Ray Smith
General Manager
Bland Shire Council
PO Box 21
WEST WYALONG NSW 2671

7 March 2019

**SUBJECT: LIGHTSOURCE DEVELOPMENT SERVICES AUSTRALIA
(LIGHTSOURCE BP) WEST WYALONG SOLAR FARM SSD 9504**

Figure 21: Construction Vehicle Access Route 1: To/From the East

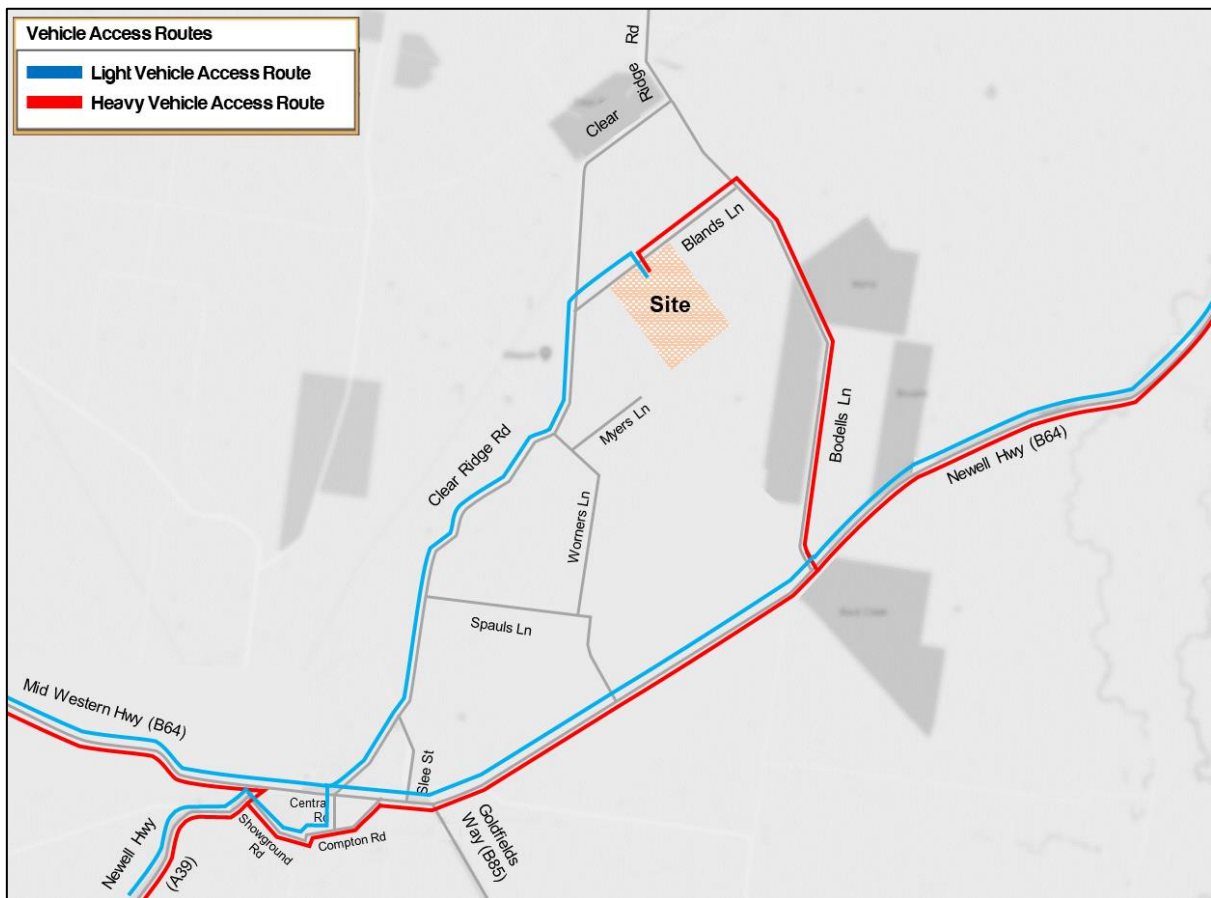
Based on the above information and traffic movements, Bland Shire Council believes that there will be significant maintenance and rectification required during and after the construction and decommission stages of The Solar Farm on Clear Ridge Road, Bland Lane Bodells Lane and Lightsource BP must cover the costs for the maintenance and rectification work.
